**7000 Acres**

**7000 Acres Response to the Tillbridge Solar Application on the subject of:**

**Socio-Economics and Land Use**

Deadline 2 Submission – 14<sup>th</sup> November 2024

**Figure 14-1: 60-Minute Drive Time Analysis from
Centroid or Order limits**

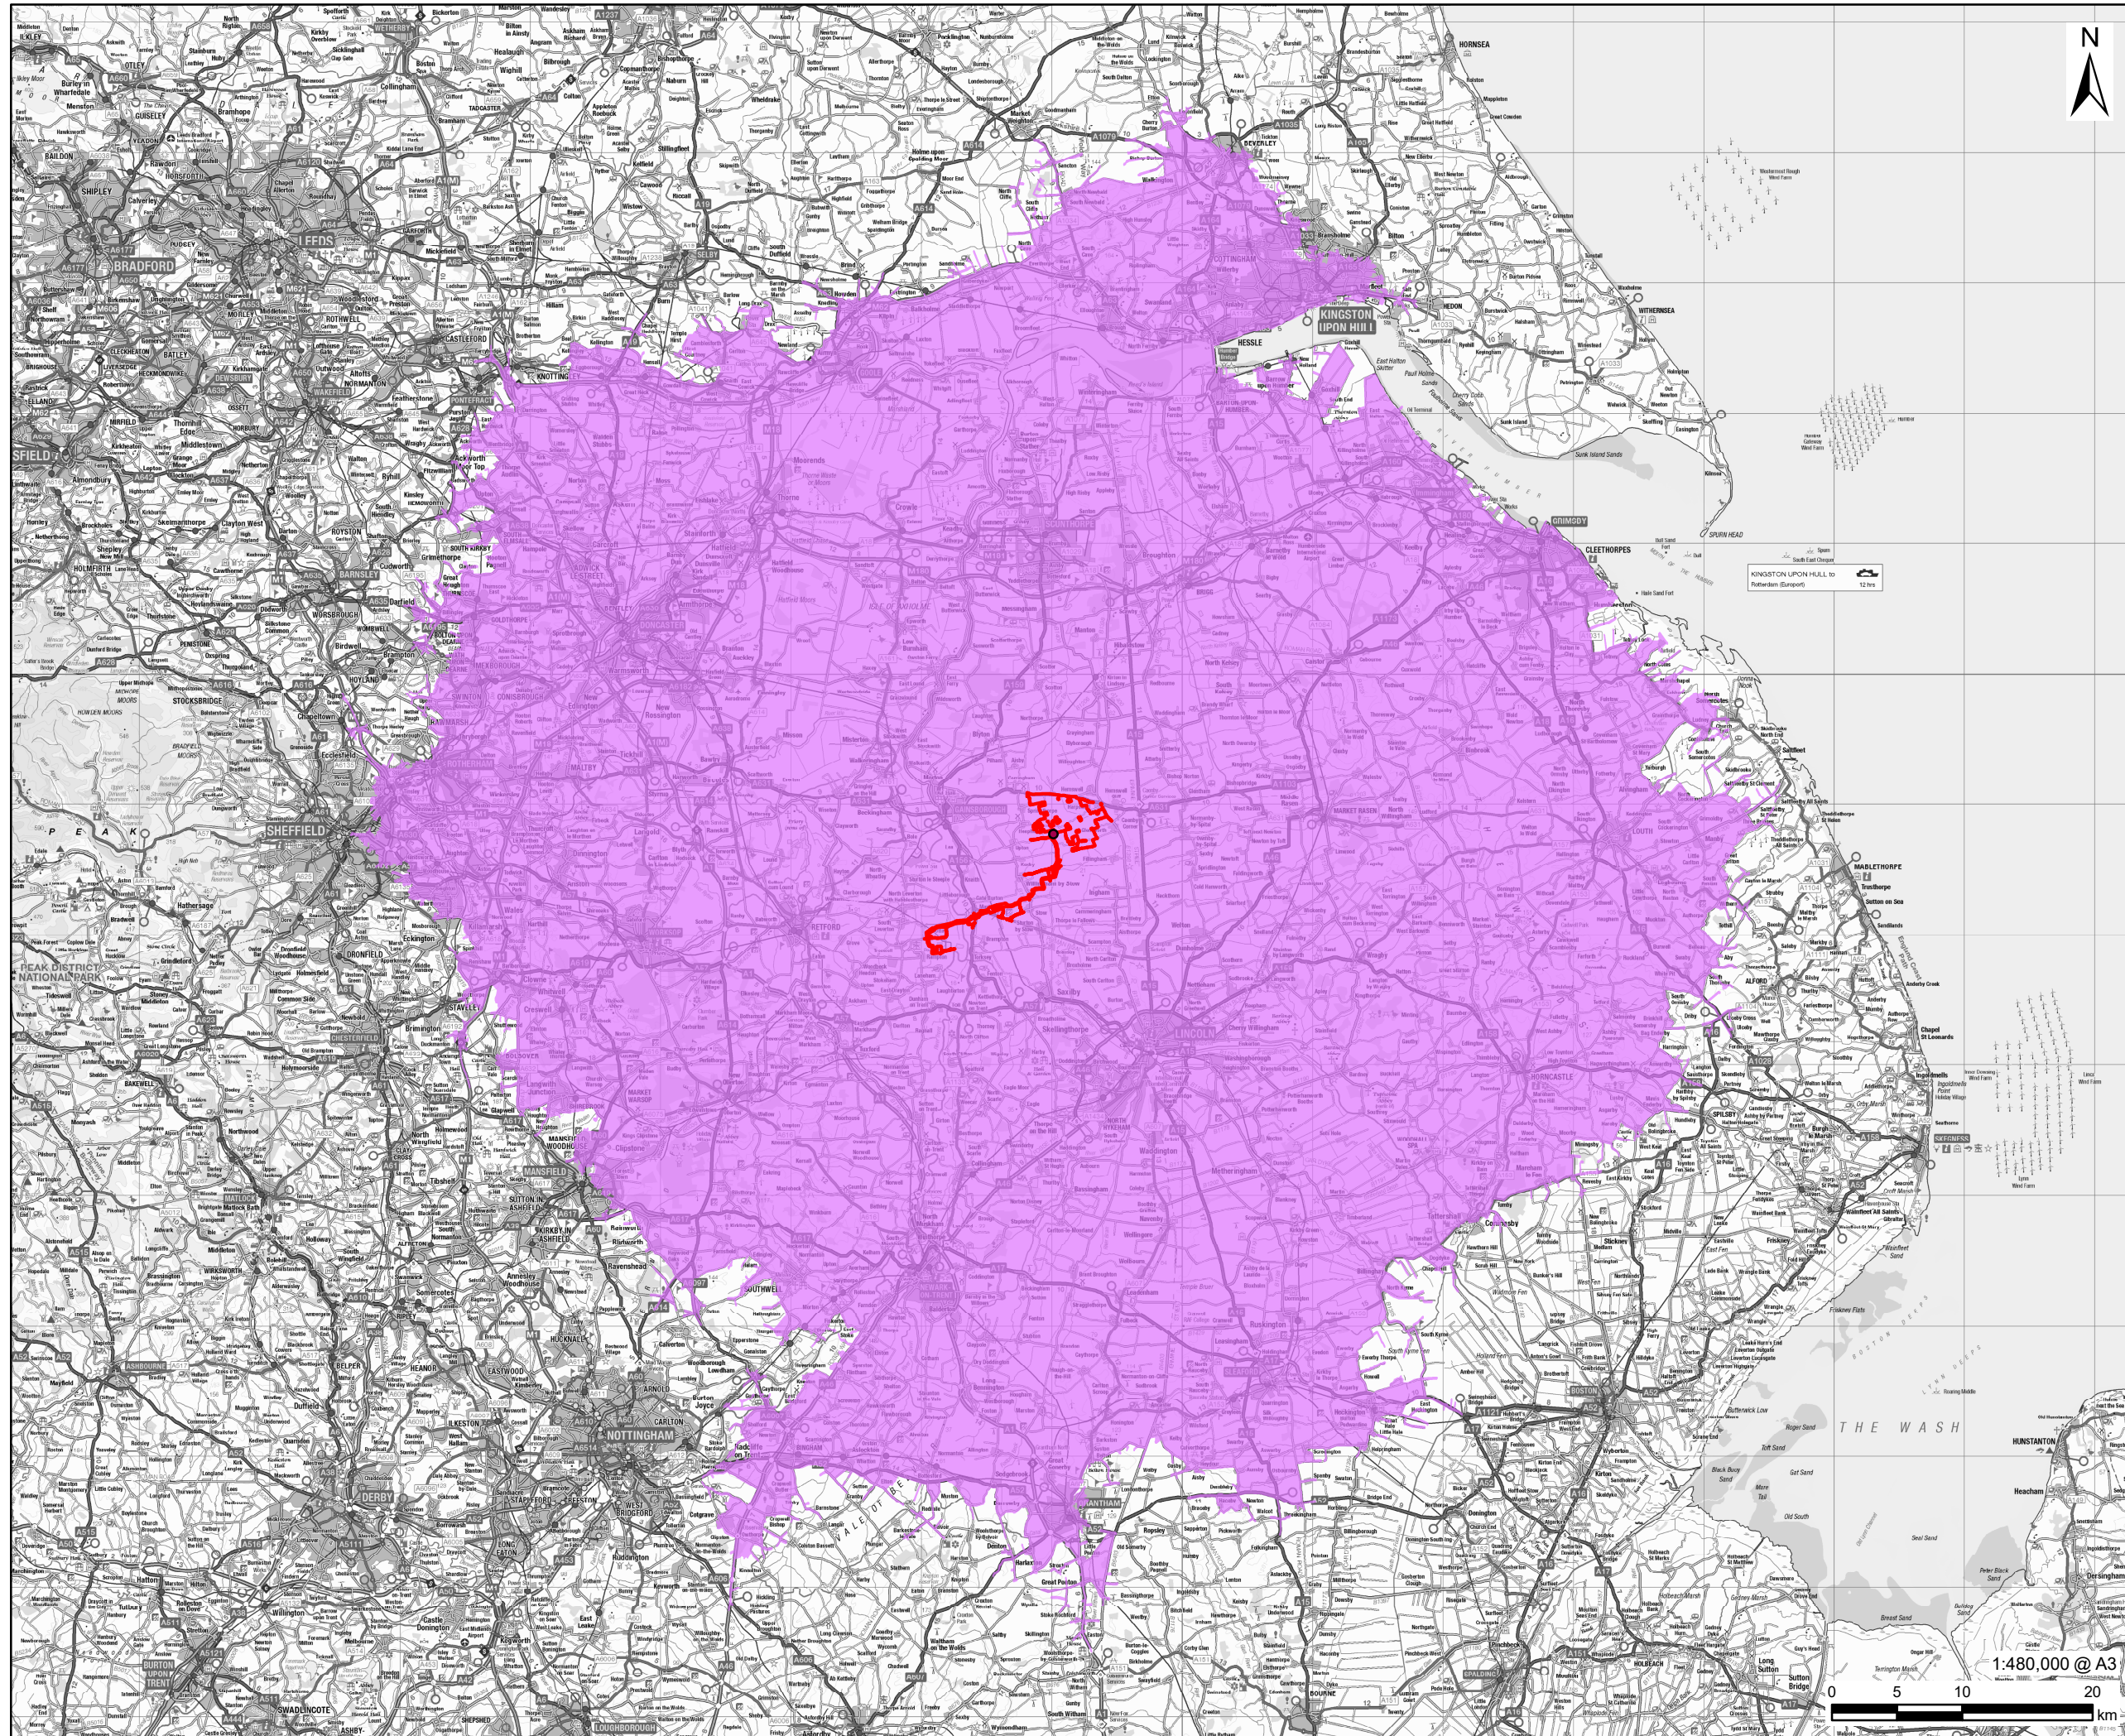
The methodology defines the Geographical Areas of Impact for various types of Impacts arising from the proposed development (shown in Table 14-1 within the ES). For the purposes of reference, the Applicant uses two diagrams Figure 14-1 (60-minute drive) and Figure 14-2 (Study Area for Socio-economics and land use effects).

- a. Area 1: For employment and GVA, the Applicant uses the concept of 1 hour drive-time as being the area of reference, making use of local district administrative areas (Bassetlaw and West Lindsey) as sources of census and deprivation data.
- b. Area 2: For “community severance”, public rights of way, local land use and amenity, the “Study Area” is used
- c. Area 3: For agricultural purposes, the impact is considered from a county council (Nottinghamshire & Lincolnshire), through region to national level.

**Area 1: For employment and GVA, Figure 14-1 within Environmental Statement (60-minute drive)**

By drawing such broad areas, there is little likelihood that such differences would be identified. These sensitivity criteria have then been applied to very specific local amenities and dimensions, changes to which will be felt overwhelmingly by the small populations in the immediate area of the scheme. The size of this population is very small, in comparison to the whole area considered, therefore the assessment of impact on the communities in the immediate area is considerably understated.

**Figure 14-2: Study Area for Socio-Economics and
Land Use Effects**

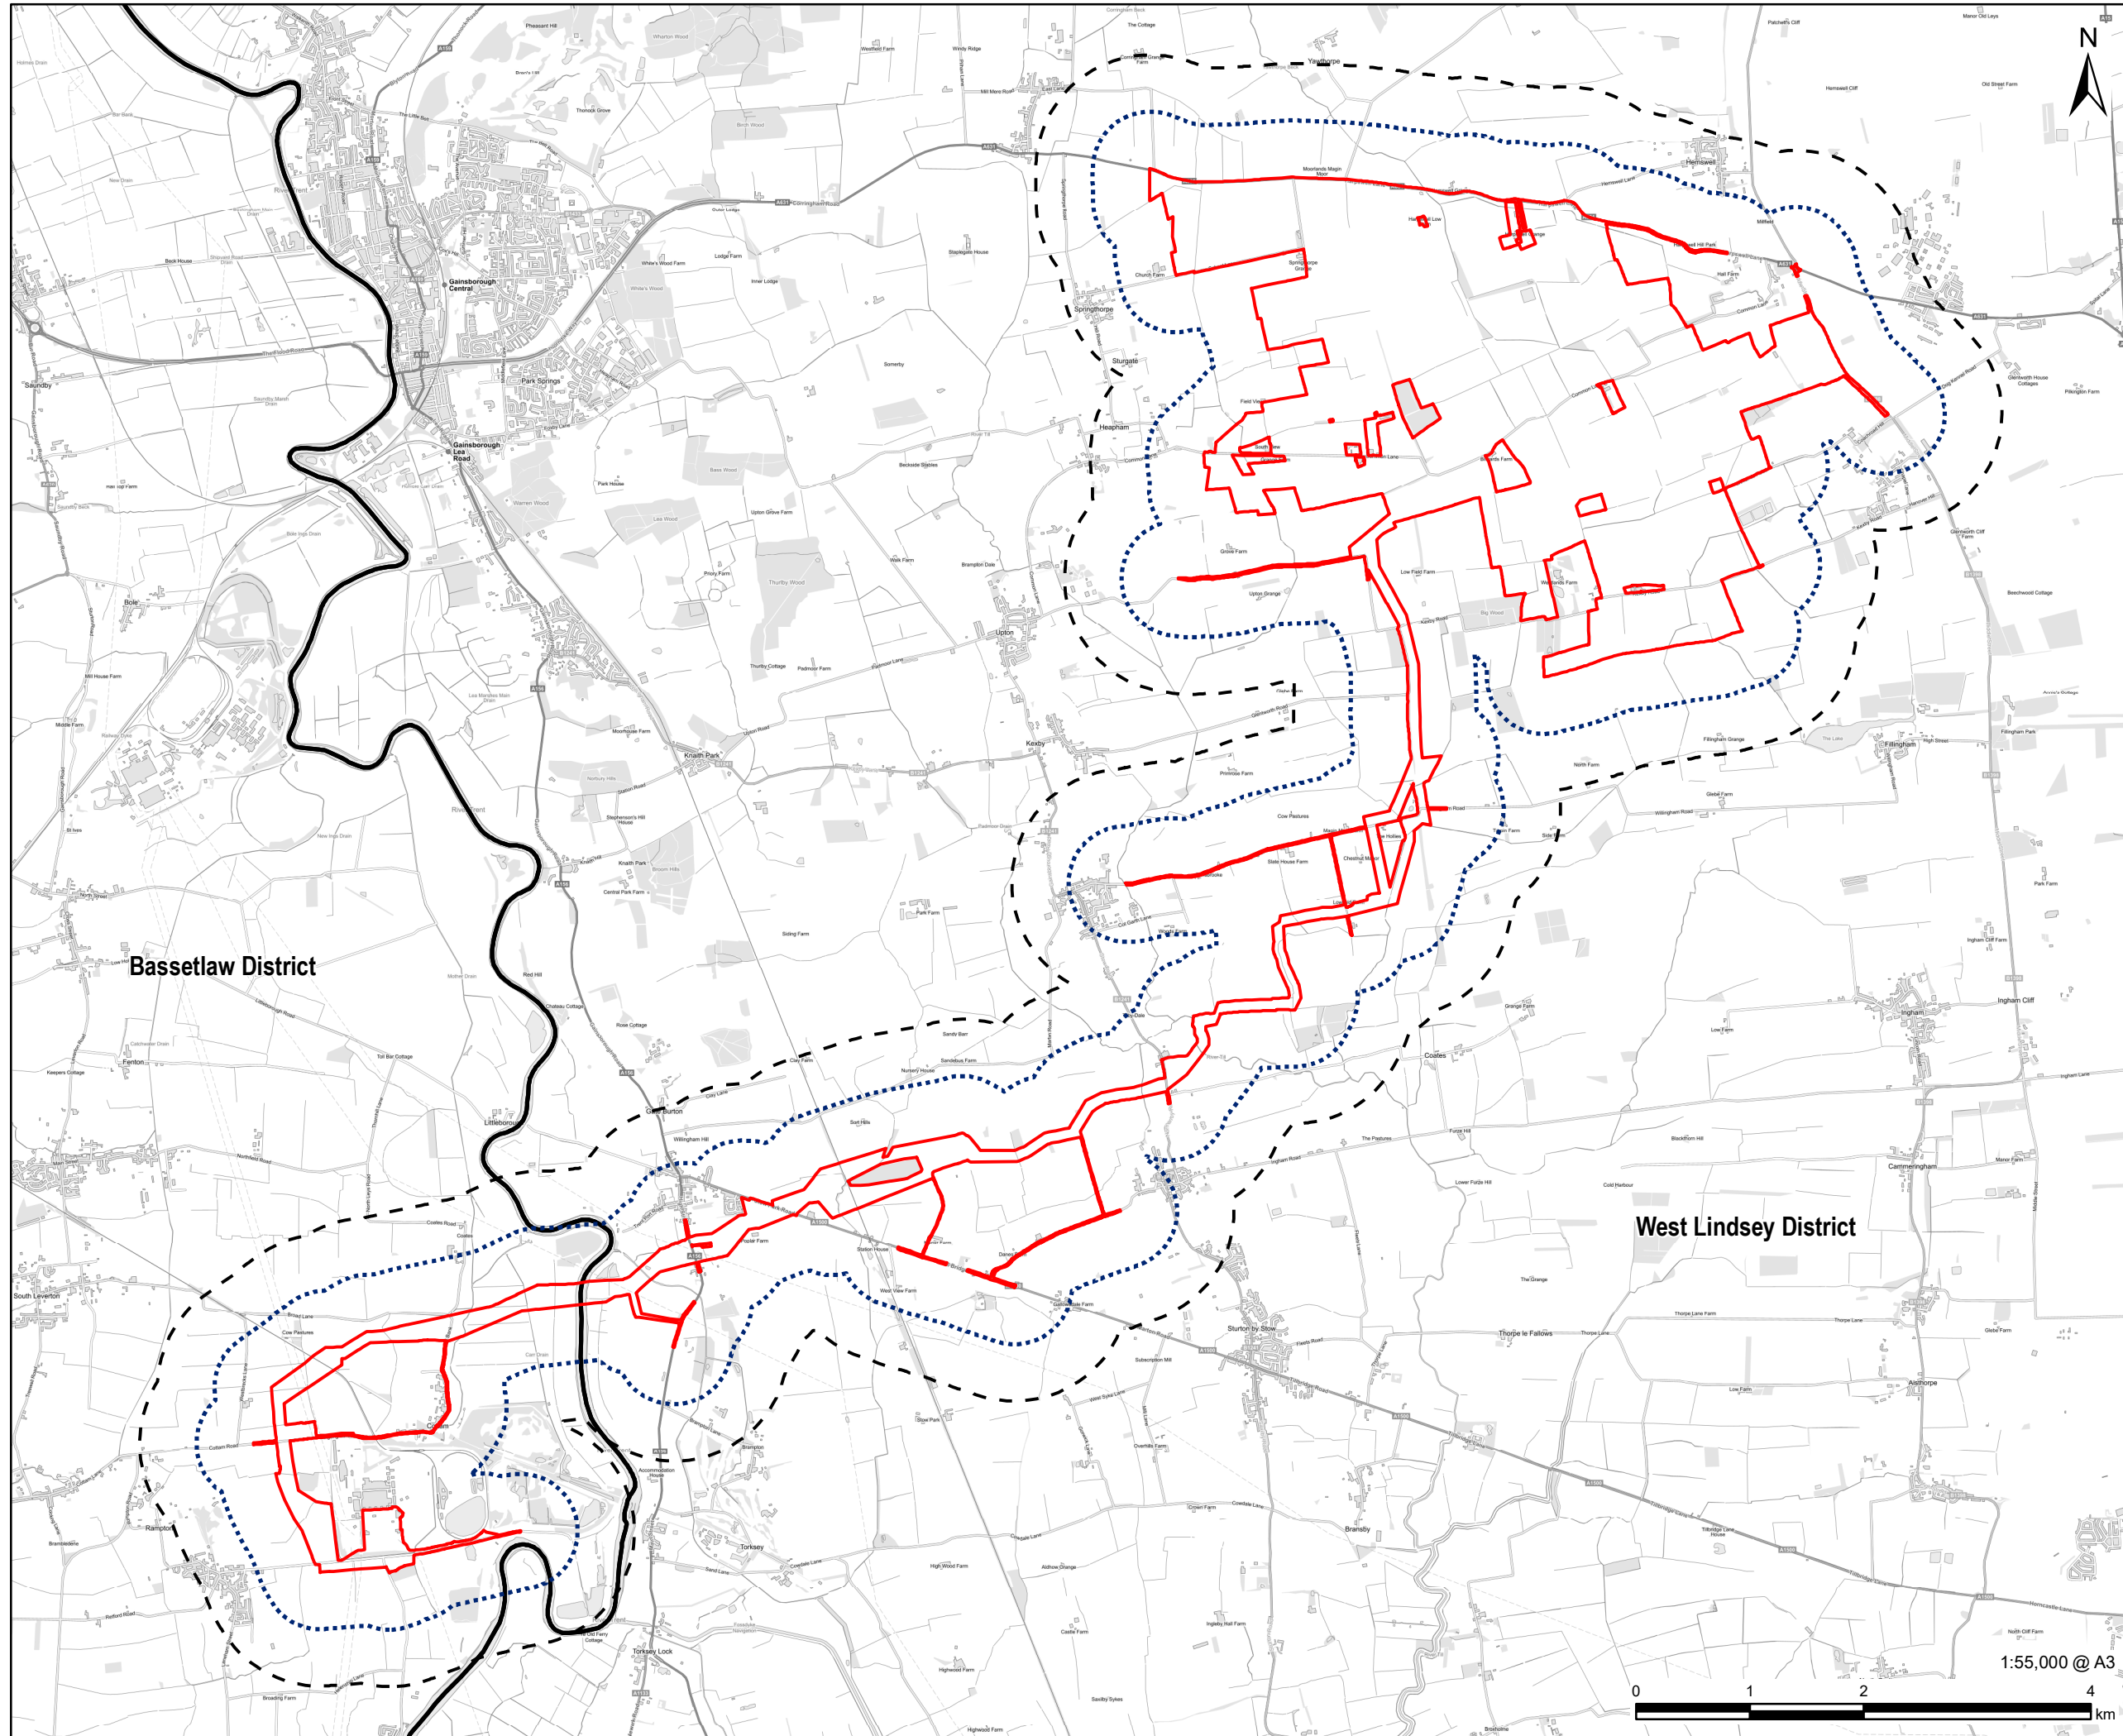
**Area 2: Used for “community severance”, public rights of way, local land use and amenity, Figure 14-2 within Environmental Statement (Study Area for Socio-economics and land use effects).**
